15th February 2024

James Royston Arboriculture Ltd

Acumen Designers and Architects Ltd
Headrow House
Old Leeds Road
Huddersfield
HD1 1SG

I write in response to consultation comments made by Kirklees officer D. Atkinson dated 6/2/24.

Client ACUMEN		
Project ERECTION OF PROPOSED DWELLING AT 33A CHURCH LANE, CLAYTON WEST		
Project No 2844	Drawing No (100)02	Rev A
Description PROPOSED SITE PLAN

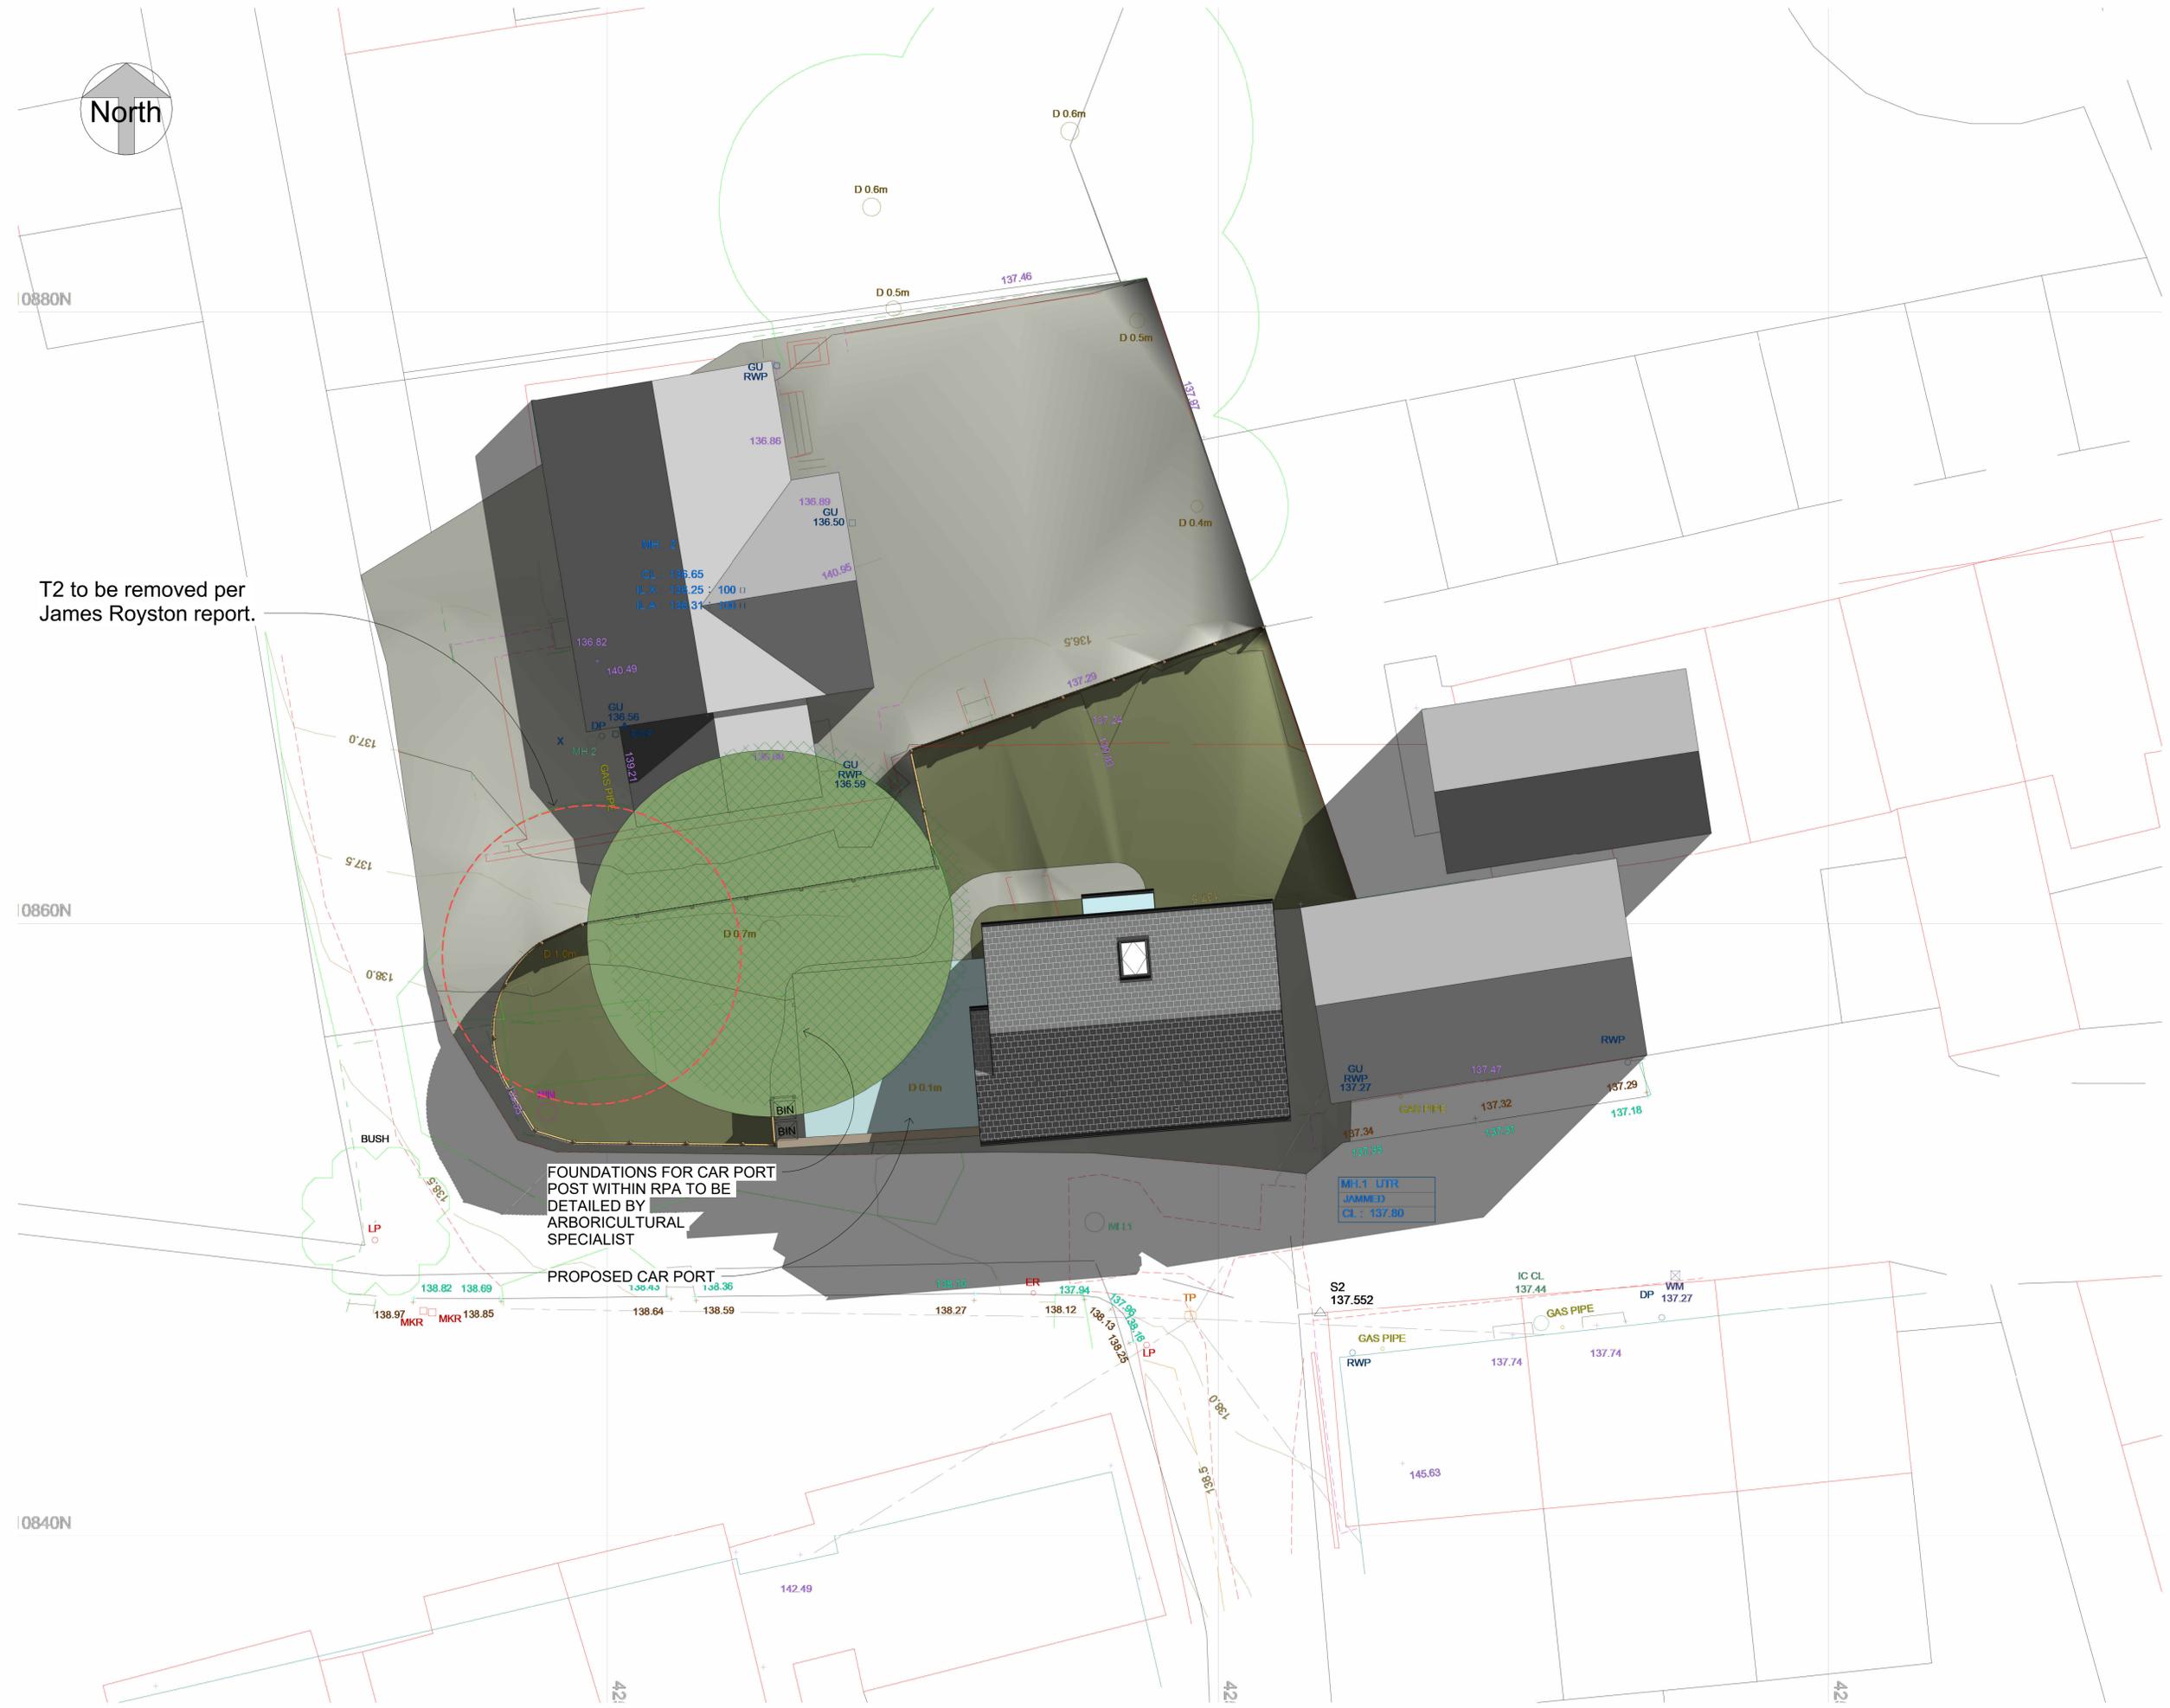
“There also appears to be change in the valuation/condition assessment of the trees between the AIA and the TS. T2 has changed from Category U in the TS to being retained within the AIA.

The recommendation at the TS stage was to remove T2, but there is no explanation for the change.”

“From BS5837:2012 section 5 (5.2.3.g) a consideration is the proposed end use of the space adjacent to retained trees.

For this development the proposed parking for the new dwelling will be under the of the Lime (T1). It will also restrict the parking of the current dwelling (33a) to being under the Lime tree and Horse Chestnut. Lime trees can drop a large amount (perceived or otherwise) of debris (i.e. twigs, epicormic growth and dead wood of various sizes).

In response to this officer's consultation response, we are now working to the belief that the tree officer agrees that tree T2 is dangerous and that it should be removed. An amended impact assessment has therefore been created which shows this tree being removed for this reason.

Additionally, the updated impact assessment shows a carport which will remove the need for these very minor implications at the proposed dwelling.
